KIRKLEES METROPOLITAN COUNCIL INVESTMENT & REGENERATION SERVICE

DELEGATED DECISION TO DETERMINE PLANNING APPLICATIONS

Reference No:	2024/62/93286/W
Site Address:	30, Midway, South Crosland, Huddersfield, HD4 7DA
Description:	Demolition of conservatory, erection of rear extension, front extension to replace porch and external alterations (within a Conservation Area)
Recommending Officer:	Joanna Rednall

DECISION – CONDITIONAL FULL PERMISSION

Date:	Scale @ A1:	Drawn by:
NOV 24	1:100/200/1250	AB
Project No:	Drawing No:	Revision:
267	(0-) 02

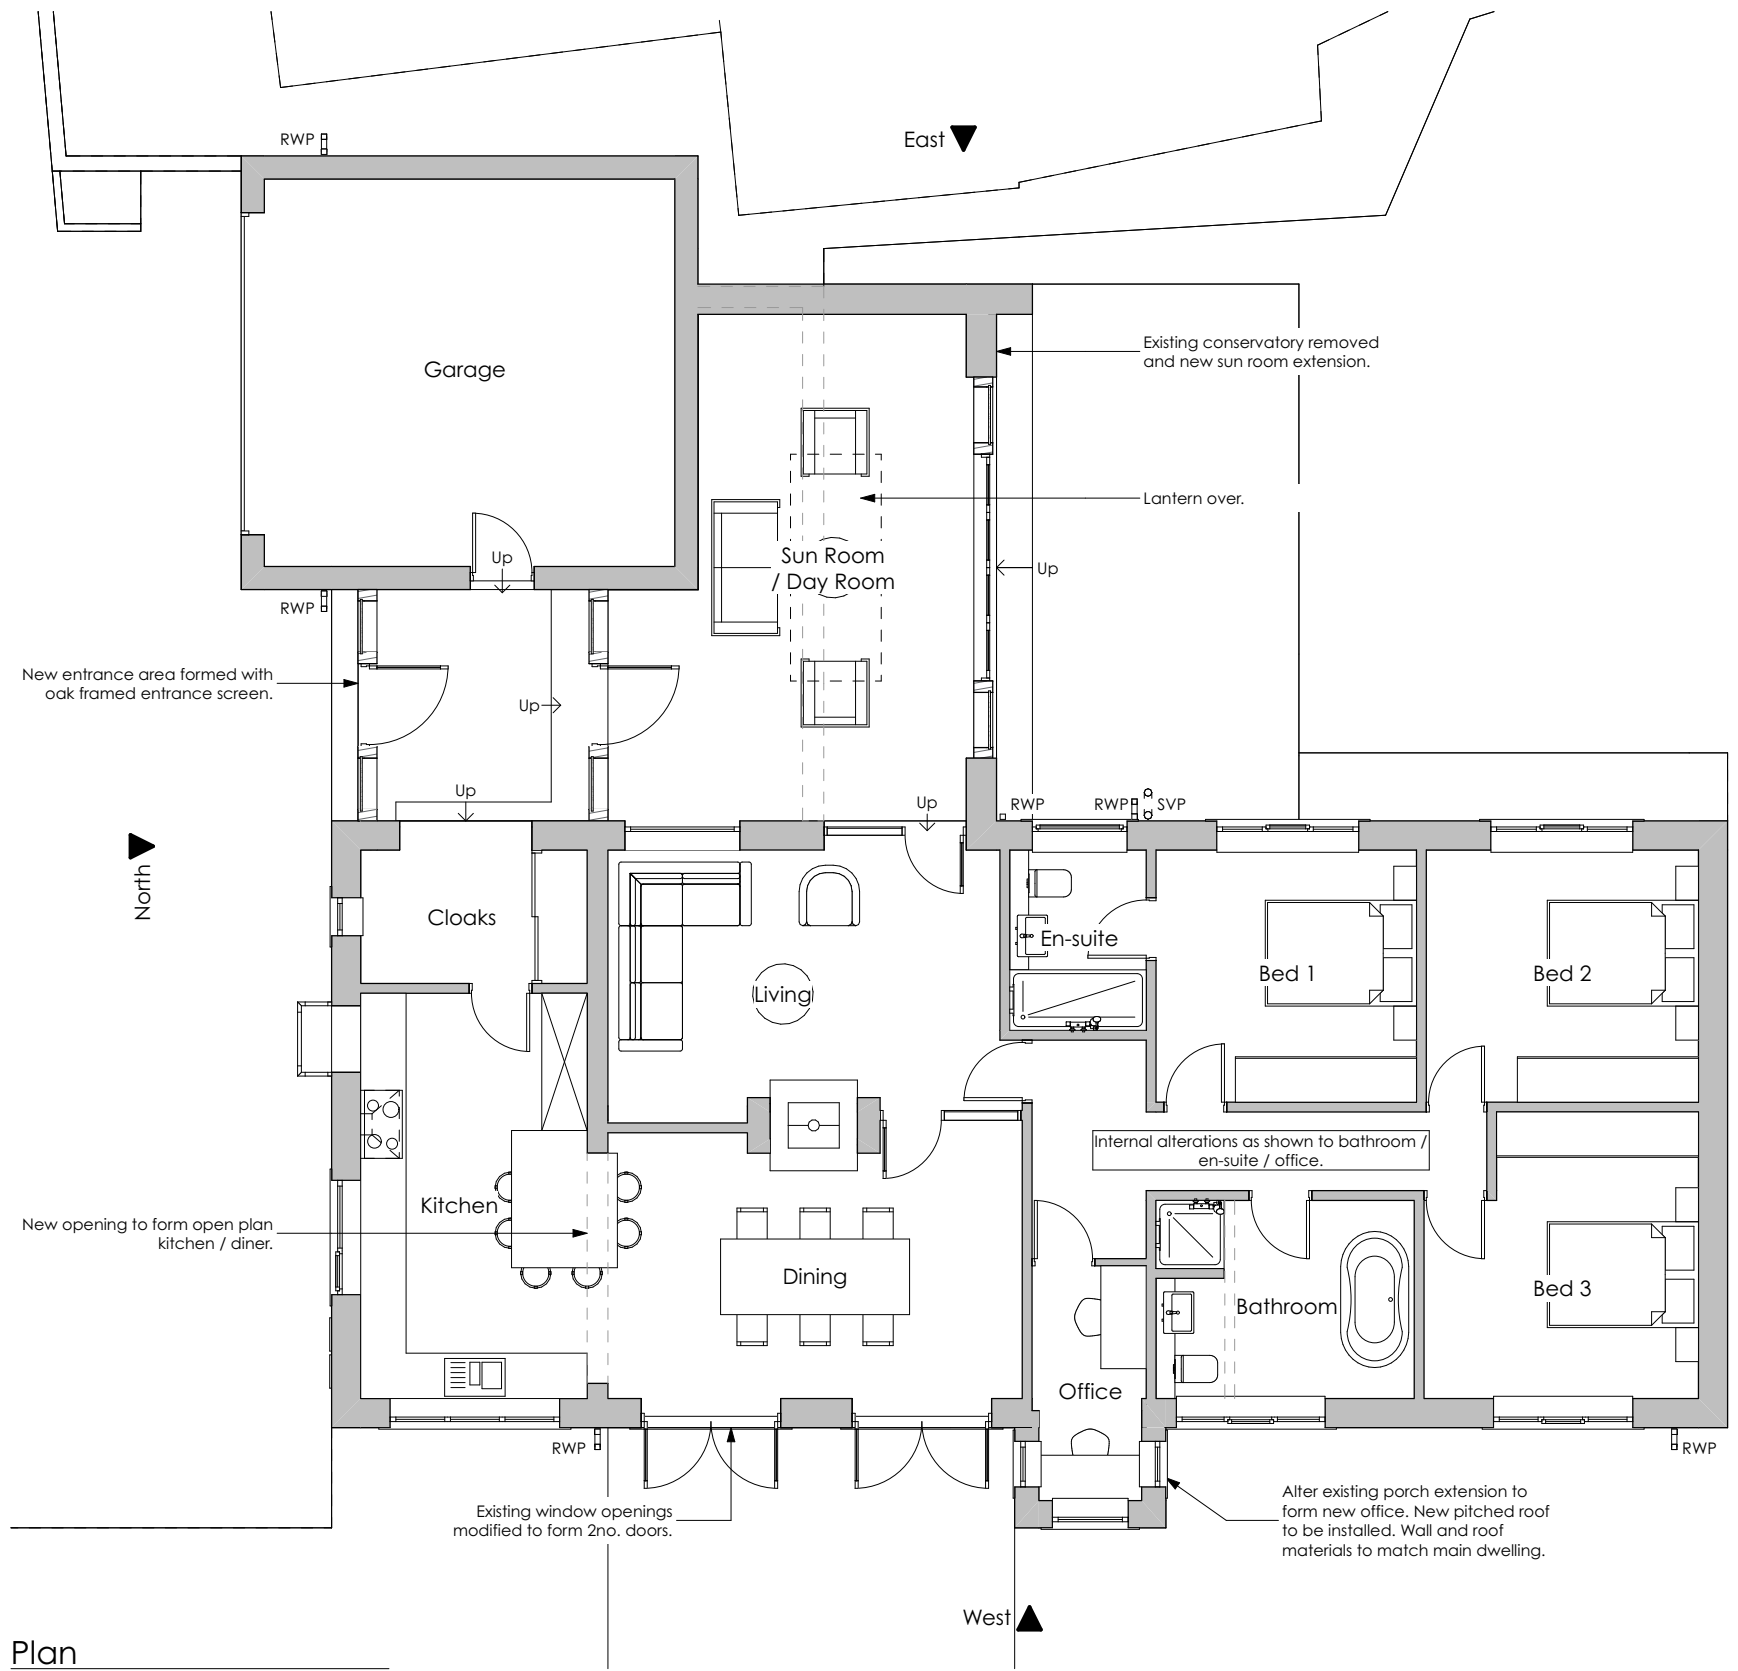
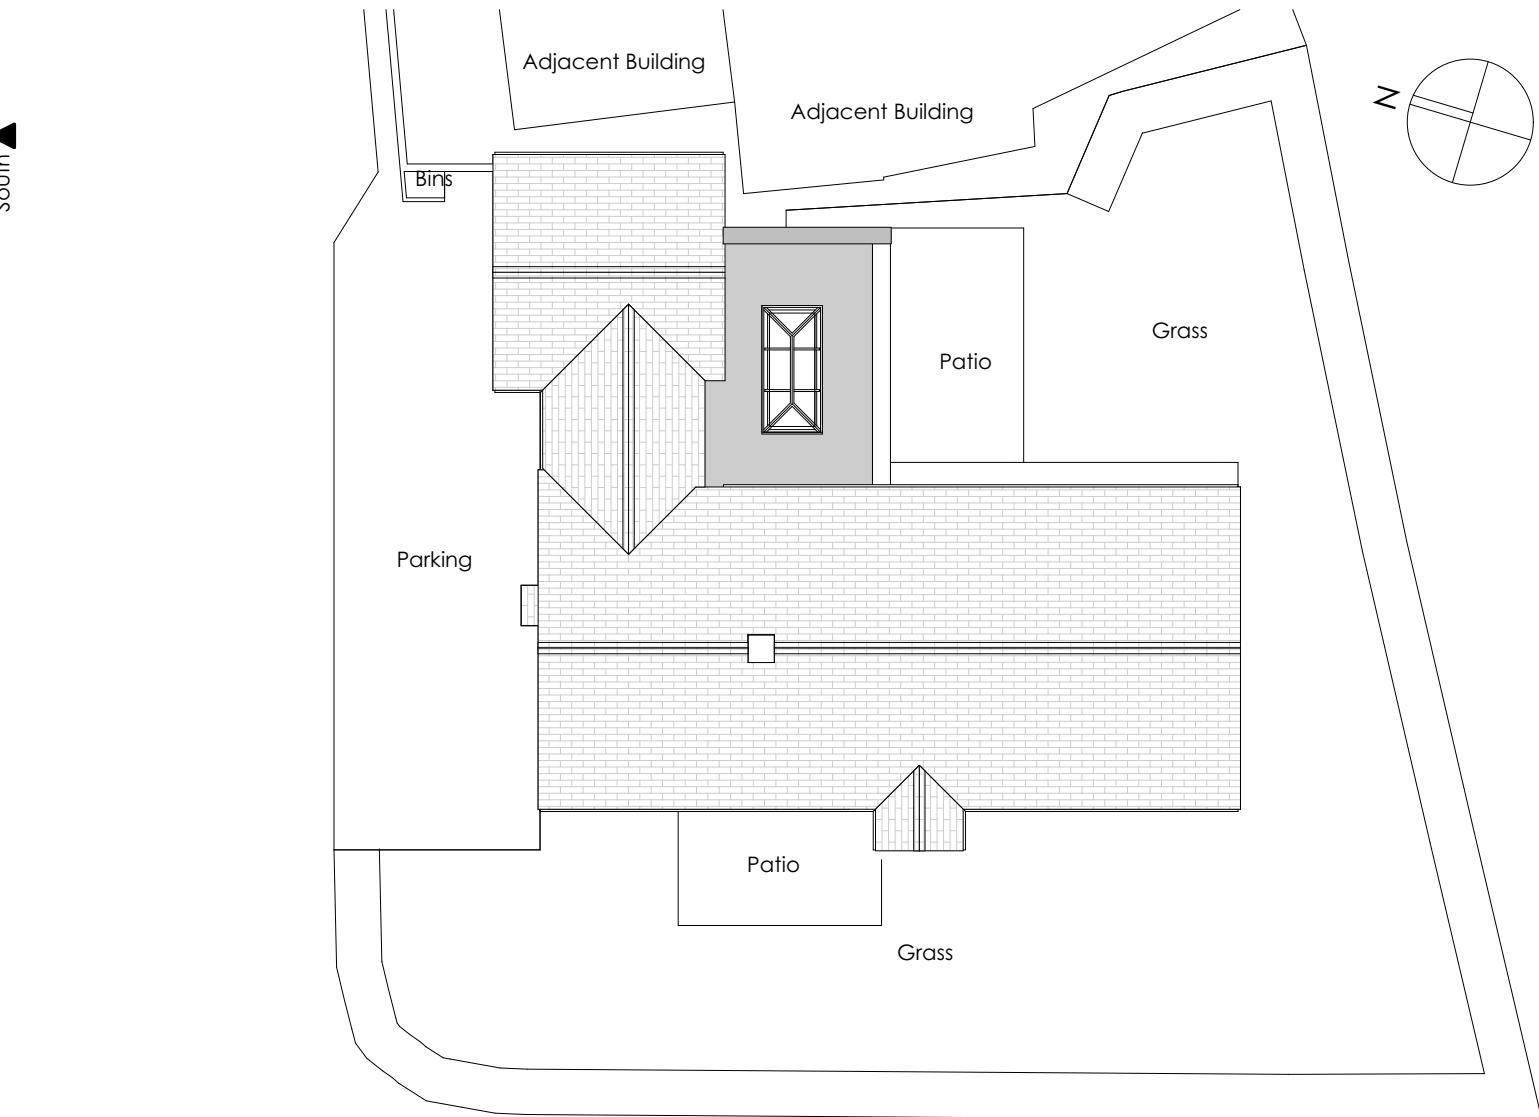
The submitted elevations show two windows on the side/west elevation would be modified to form two sets of glazed patio doors in grey casing, and one small window is proposed to the front elevation. These alterations are considered to be acceptable in terms of visual amenity due to the position of the property in the street-scene and the varied nature in terms of design and scale in the vicinity.

Submitted drawing ref (0-) 02 sets out materials of construction, which details all materials which would be to match the host property / introduction of new materials. The material palette is considered to be acceptable and a condition requiring this is they are undertaken as per the submitted plans is recommended.

3. The materials of construction of the development hereby approved shall be in accordance with those set out within submitted drawing titled 'Scheme as proposed' ref (0-)02 and completed prior to the development being brought into use.
